Your Ref: OWPC21918
Our Ref: BR/49/19/OUT 13-02-2019
Please ask for:
Mr S Davis

Outline application with all matters reserved for 22 No. new dwellings consisting of 2 No. 1 bed dwellings, 18 No. 2 bed dwellings & 2 No. 3 bed dwellings.

26 Burnham Avenue Bognor Regis

Thank you for your internet representation made on 31st March 2019 which has been recorded as '**an objection**' with the comments as follows:

West Elevation BLOCK A (Proposed) 1:100
0 2.5 5.0 M

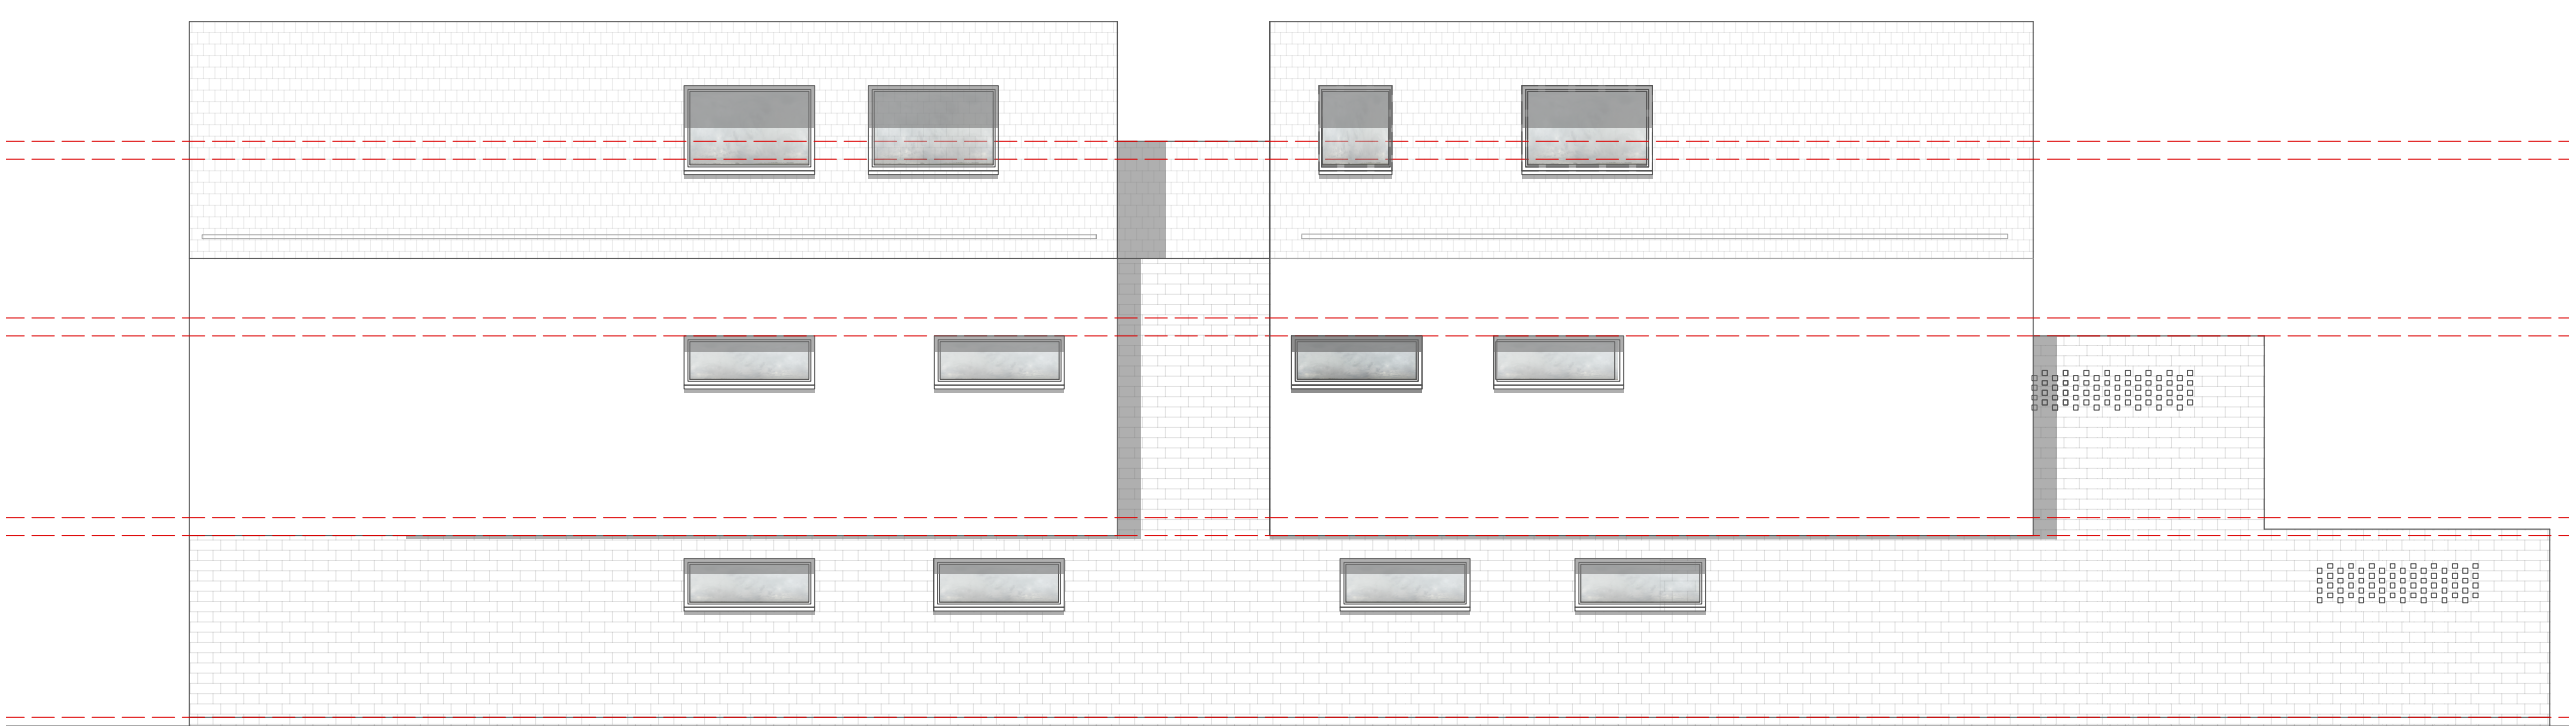
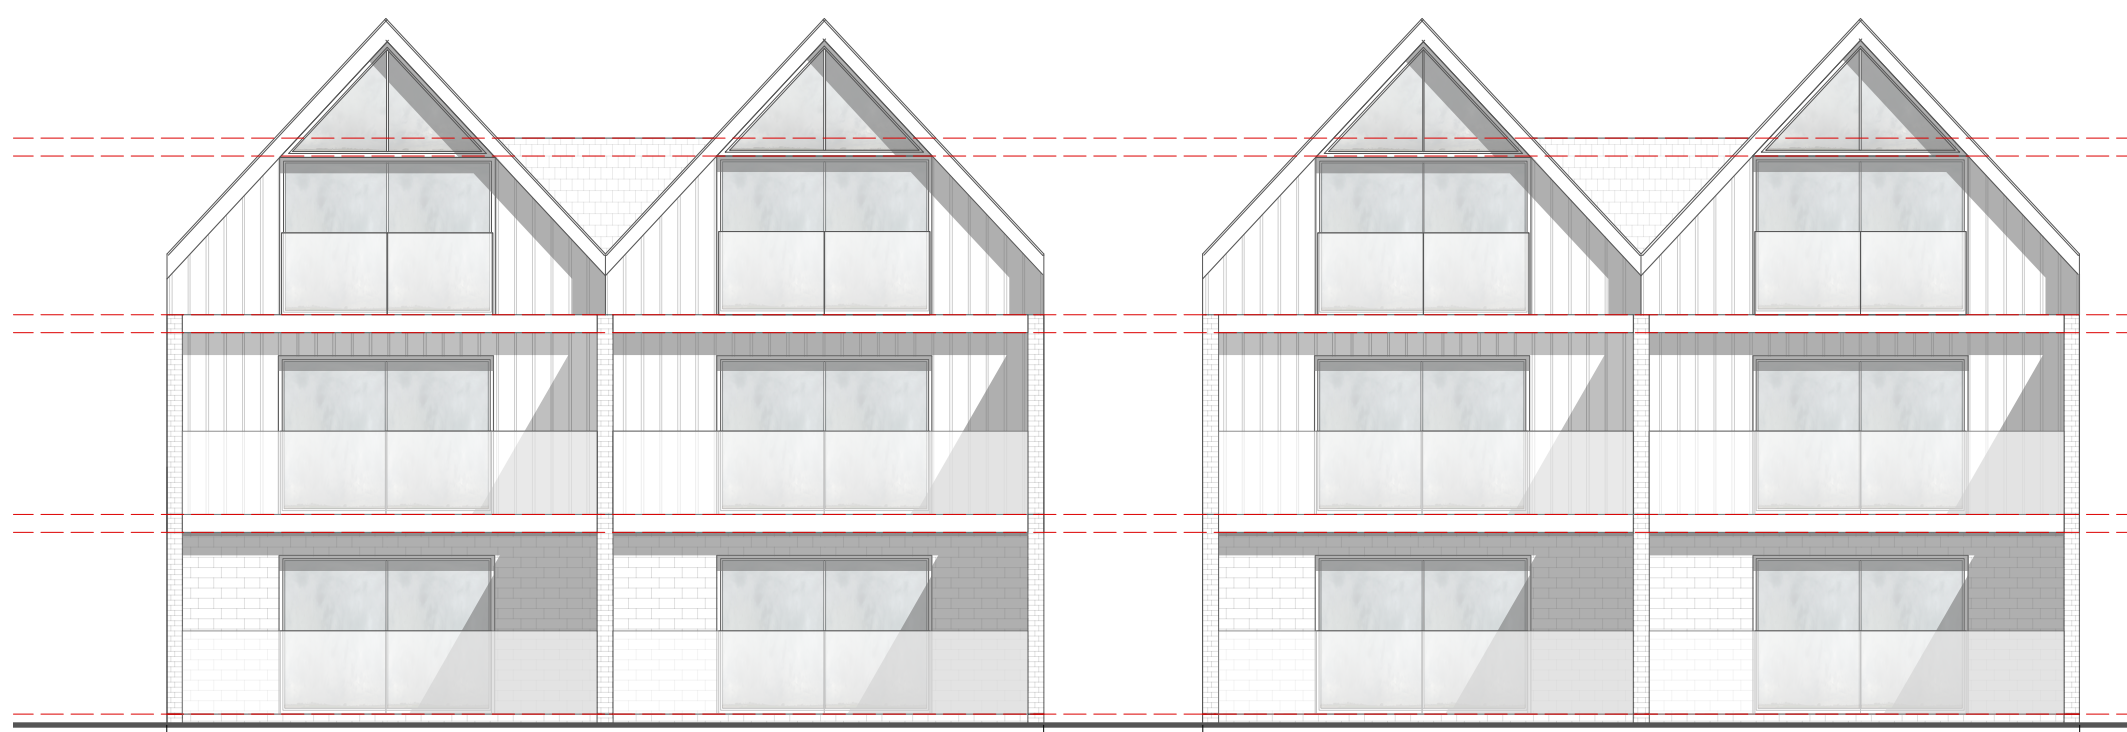
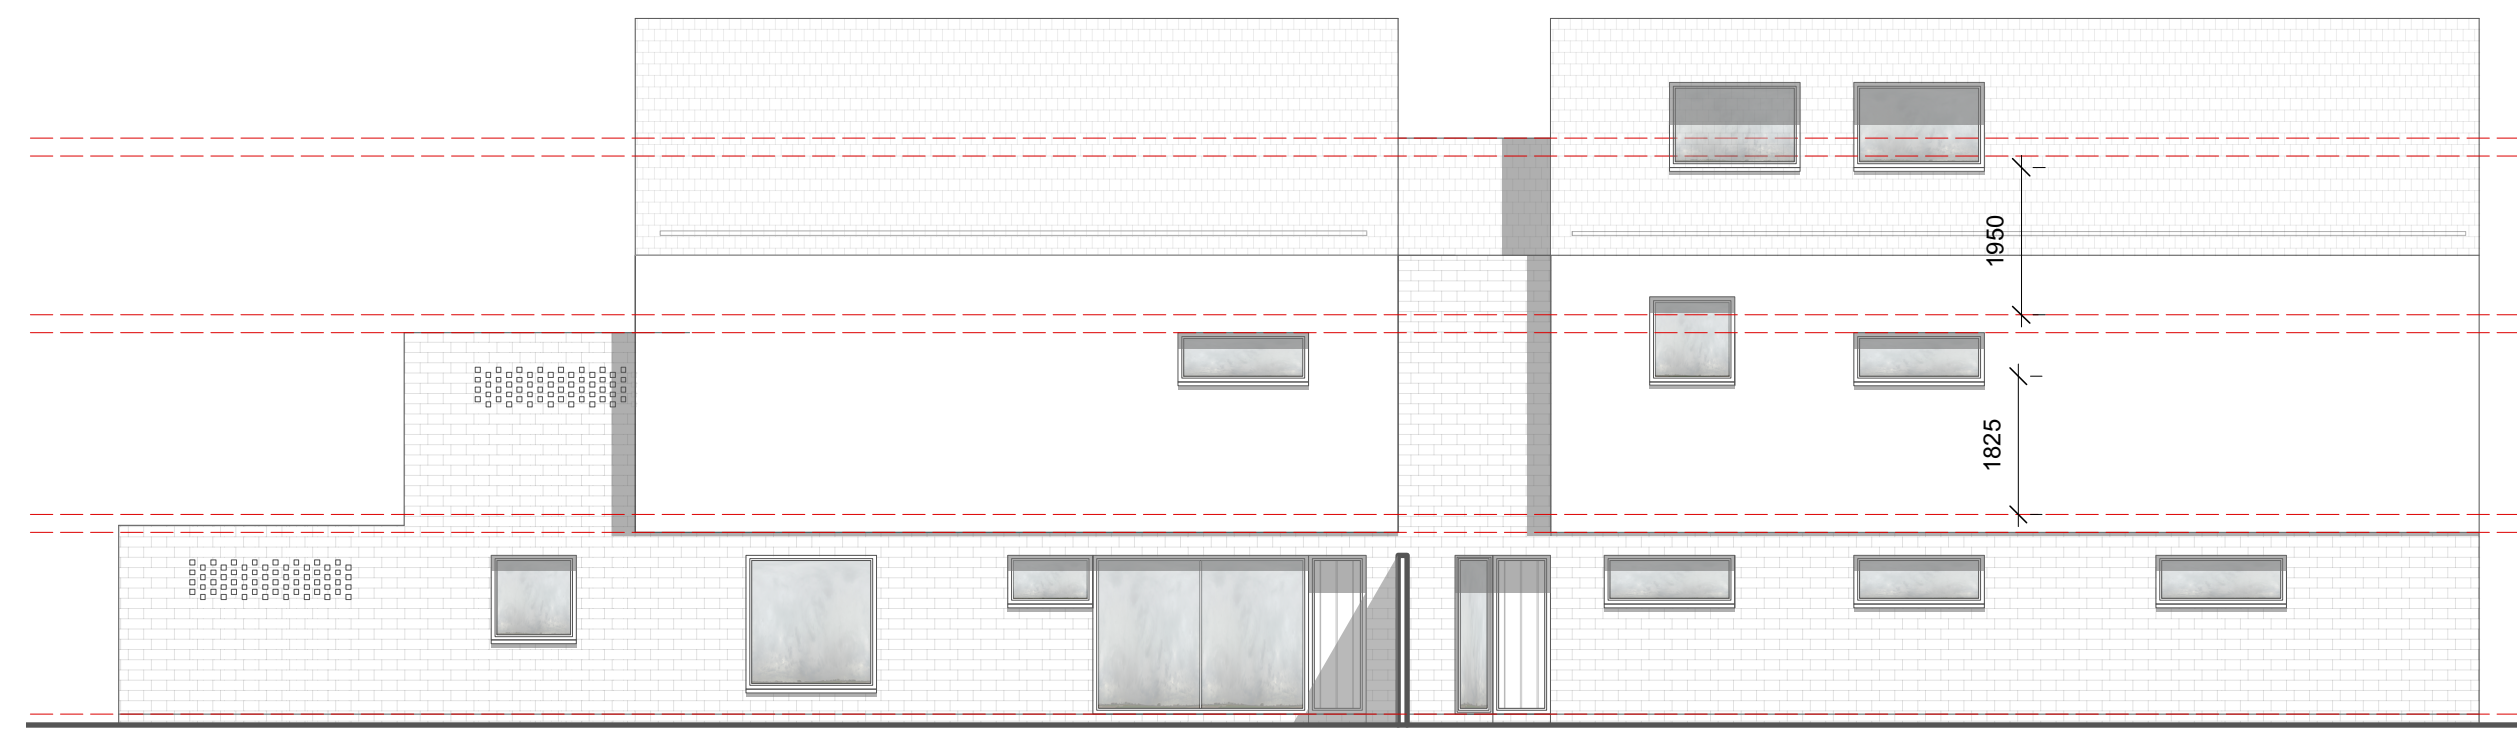
- 1. Lack of parking, already a major for this road and the surrounding roads.*
- 2. Over development. Doctors, nursery etc already full*
- 3. Balconies that will overlook other residents at the back.*
- 4. Taking away from the history and aesthetic of the roads houses, whilst there are some flats (with adequate parking), most properties are family houses and so this does not match the road and area.*
- 4. There has been no physical signage near the proerty referencing the planning application, which I believe is required. (Usually a yellow type sign on a post) Therefore very few people are aware, as the owner has not made it 'public' as I have seen every other time planning applications have been put in in the town.*
